RE: Planning Application 23/02258/HOU - more information is needed

Your ref: 23/02258/HOU

7. please note; although the existing rear extension is to be altered, we aim to retain as much as the existing superstructure as practically possible. The proposed works are; Two storey extension to rear, with external and internal alterations.

DWG. TITLE: EXISTING ELEVATIONS + SITE LOCATION PLAN

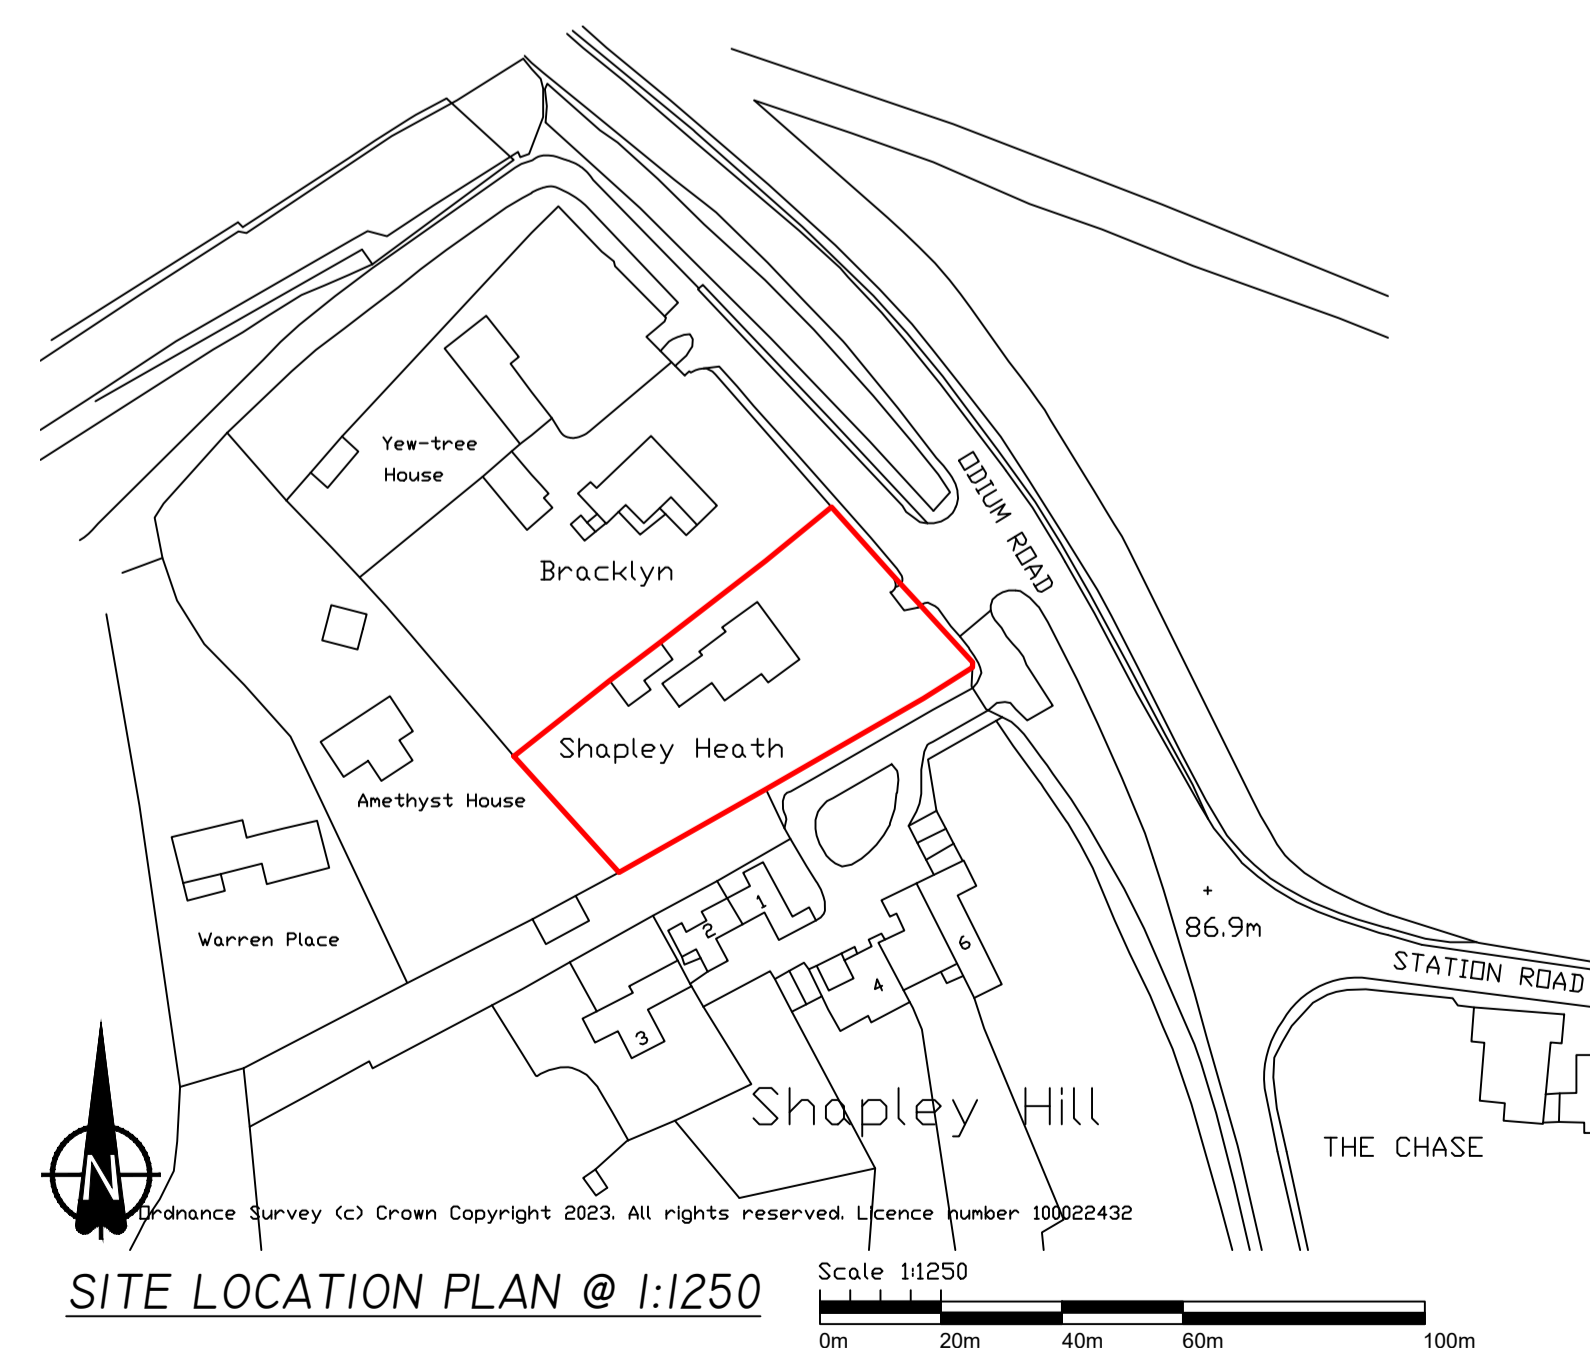
1. I am informed by the applicant, the site does not share a common private access.
2. The site location plan has been amended to show at least two road names as requested. (as shown on historical applications)

DWG. TITLE: PROPOSED ELEVATIONS + BLOCK PLAN

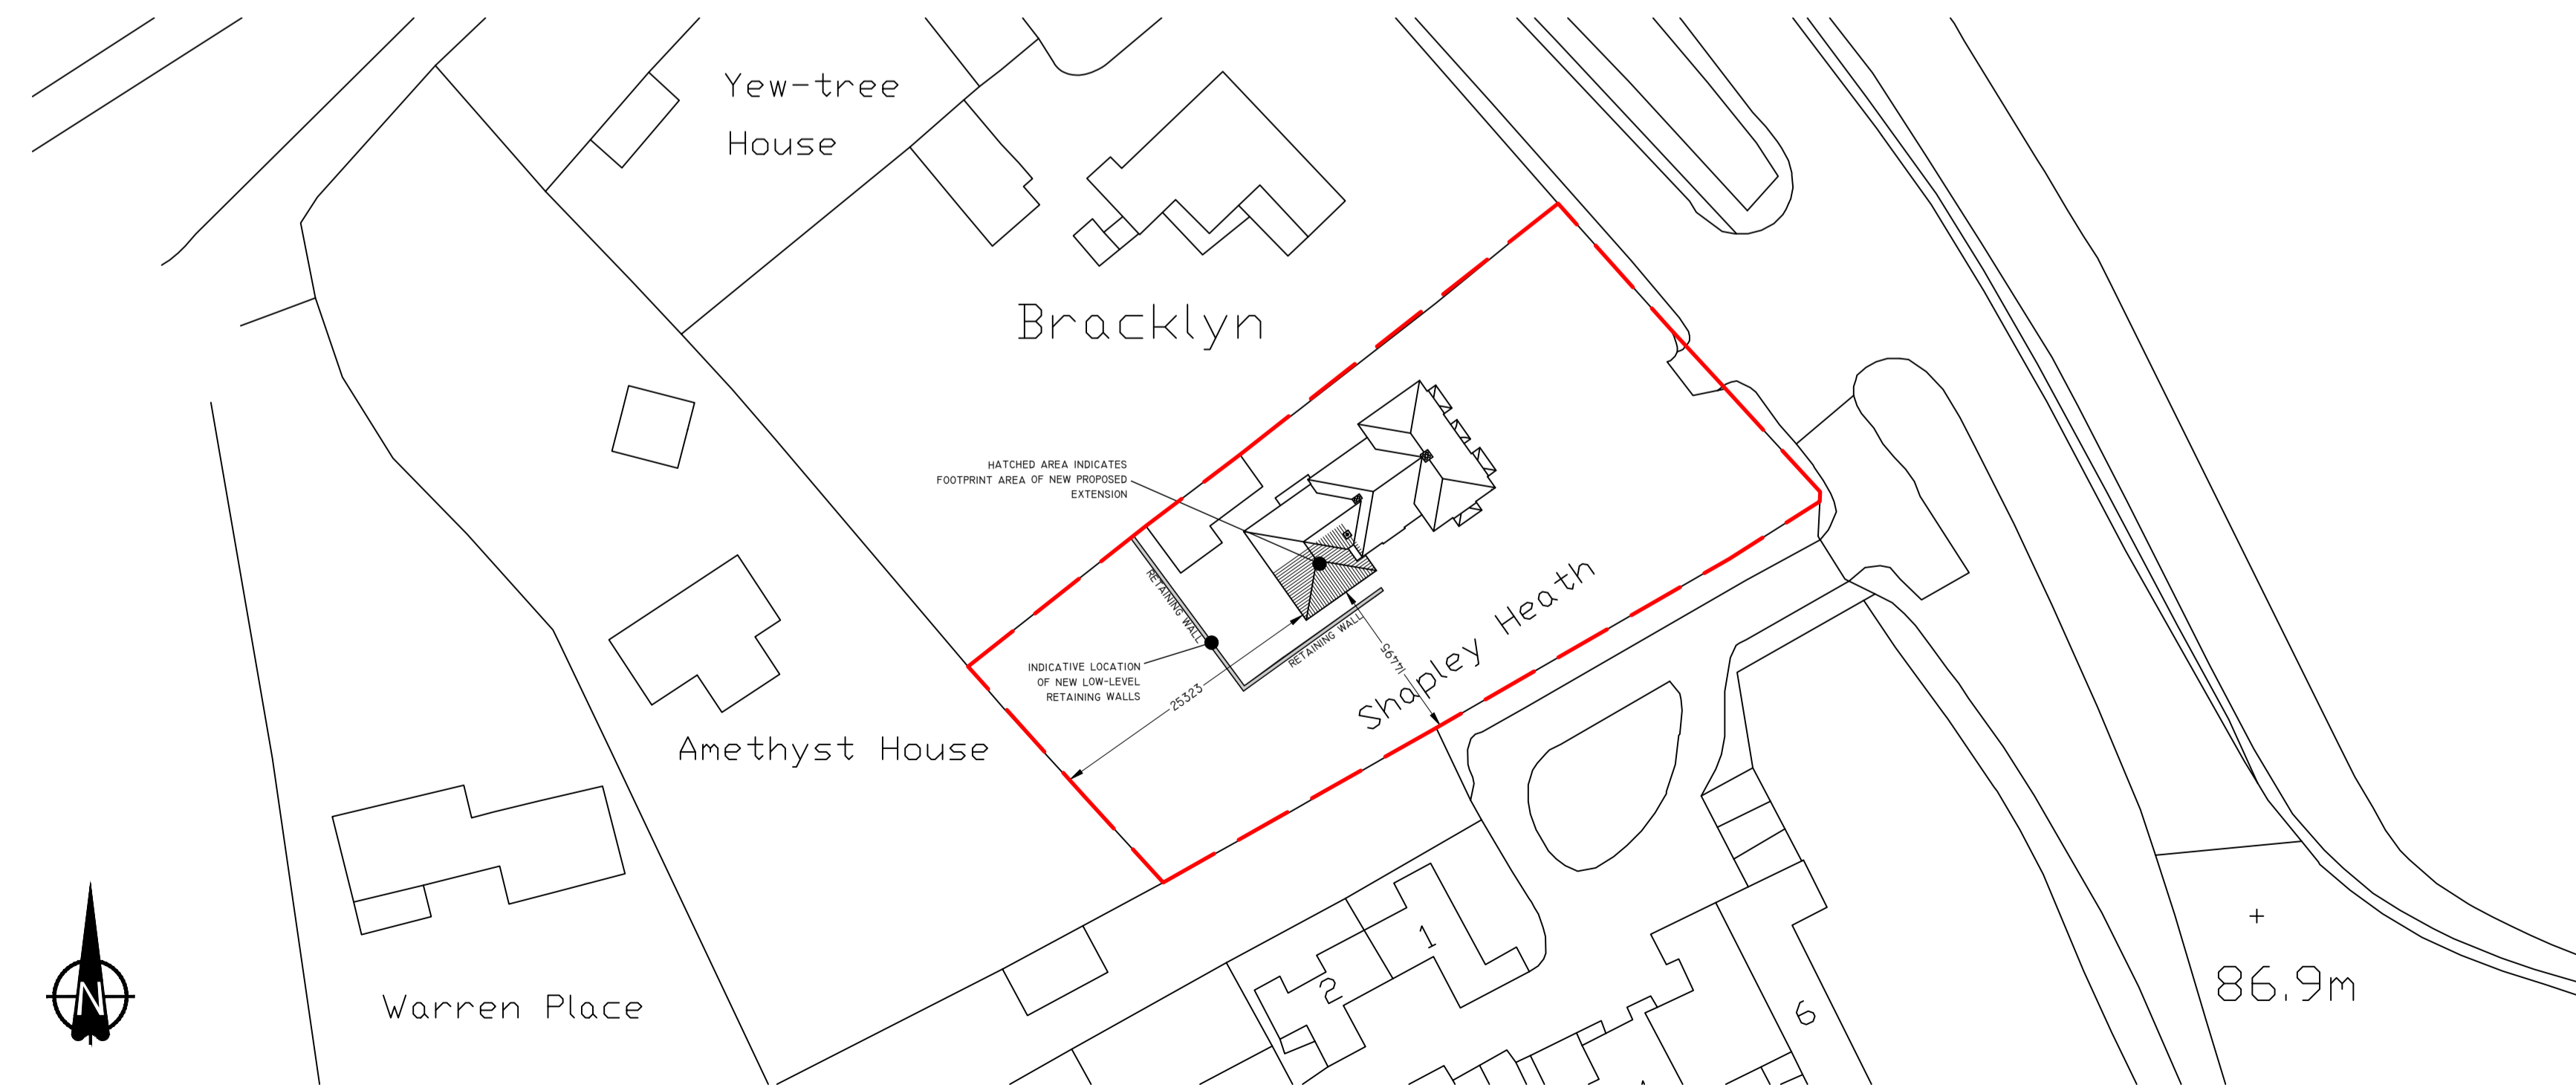
3. Dimensions have been added to the block plan as requested.
4. With reference to the requested section; Side elevation B has been modified to show the difference in levels and the sloping elevation up to the rearward site boundary.
